Our Ref: BR/206/19/PL

**Town & Country Planning Act 1990 (as amended)
Town and Country Planning (Development Management Procedure) (England) Order 2015
Application for Planning Permission**

Development	Extensions & alterations to shop & HMO to reduce shop & form 8no. self-contained flats.
Location	83 Aldwick Road Bognor Regis

Side (west) Elevation
Scale 1:100

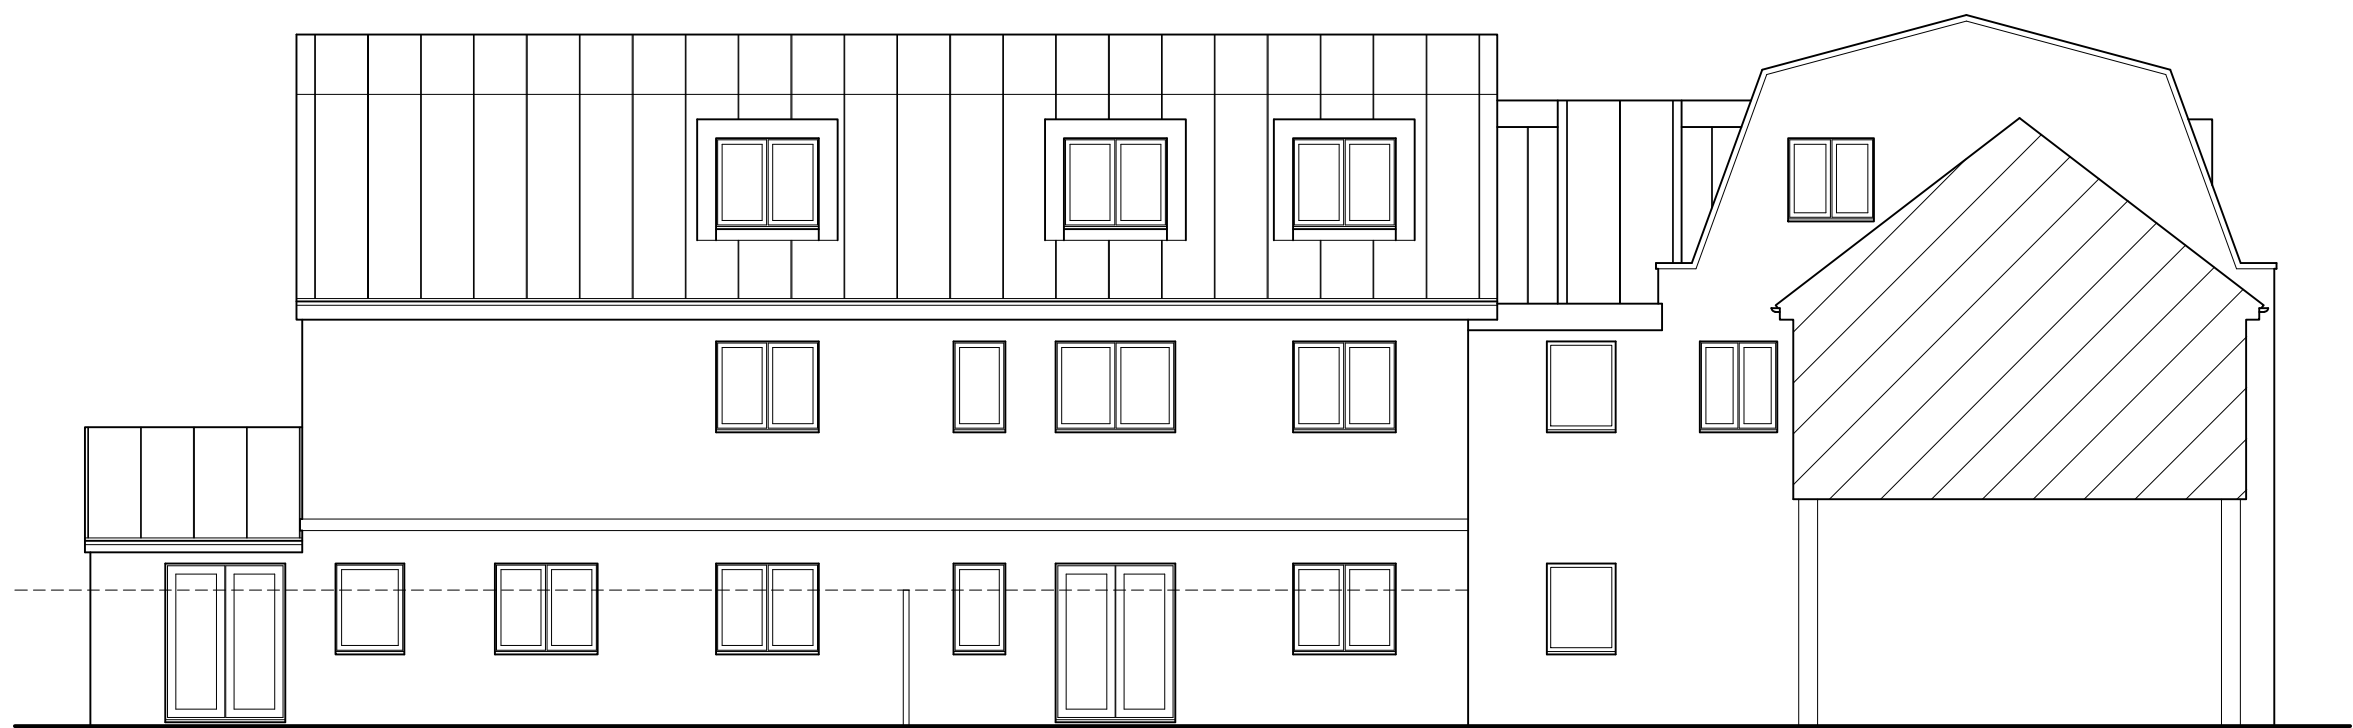
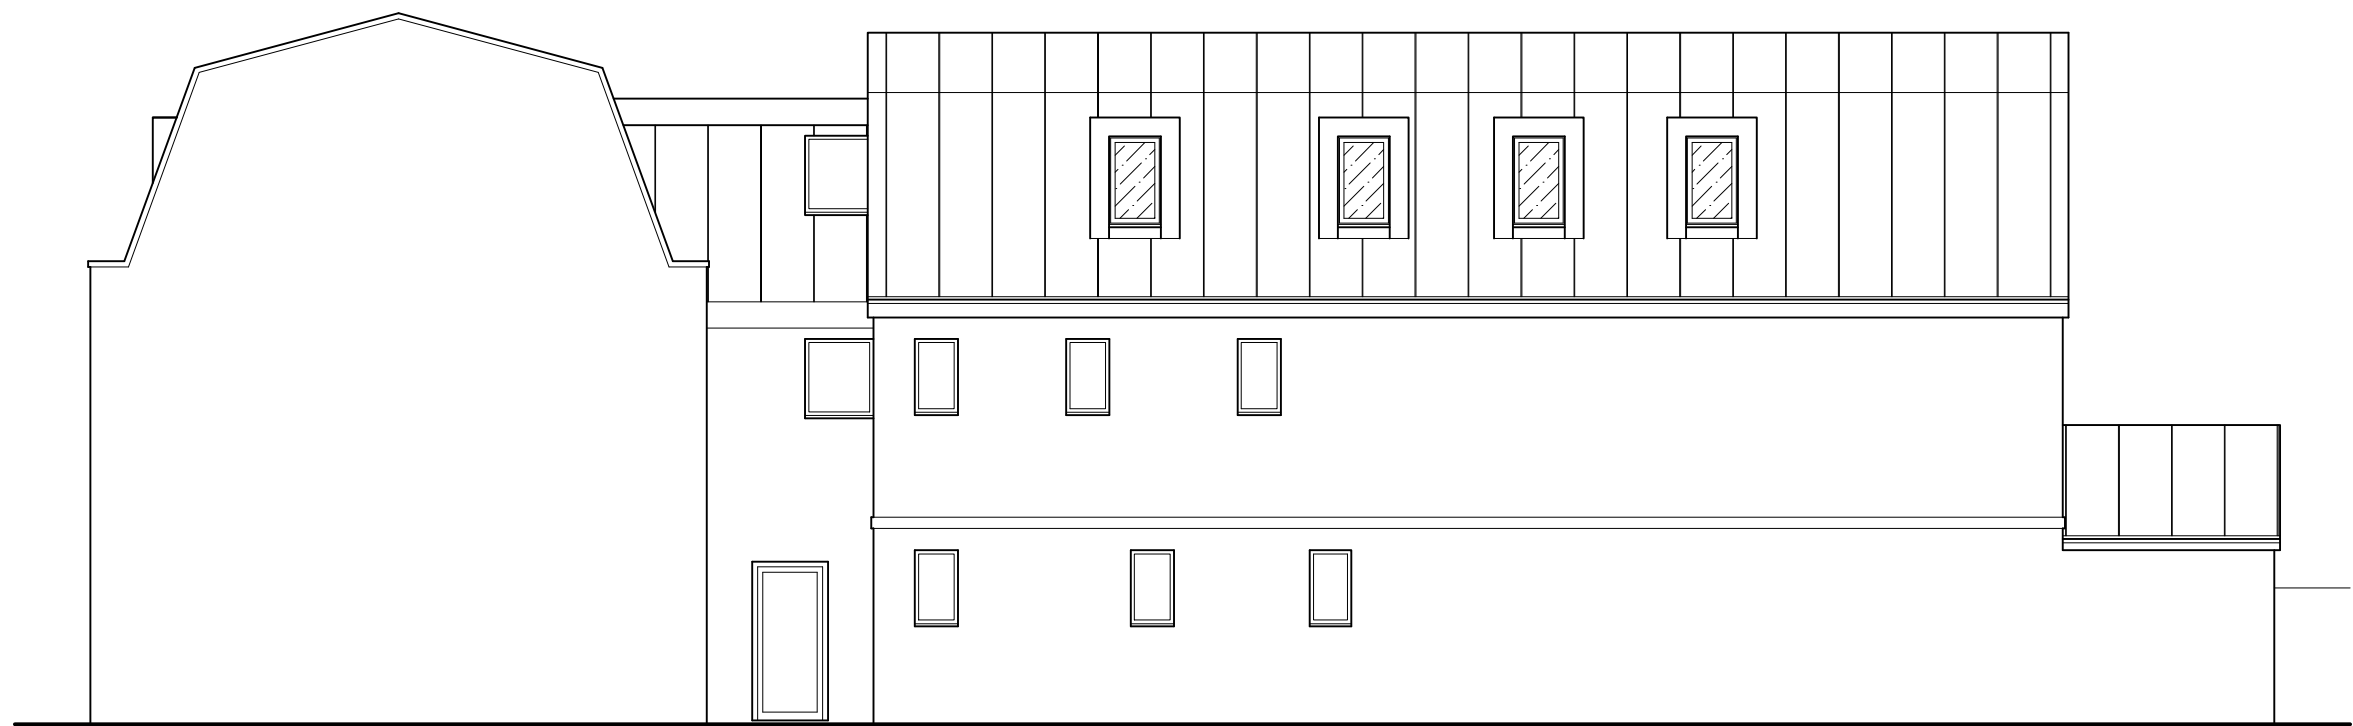
The ground floor west elevation & ground floor plan do not accord (missing small window). Please forward amended plans accordingly.
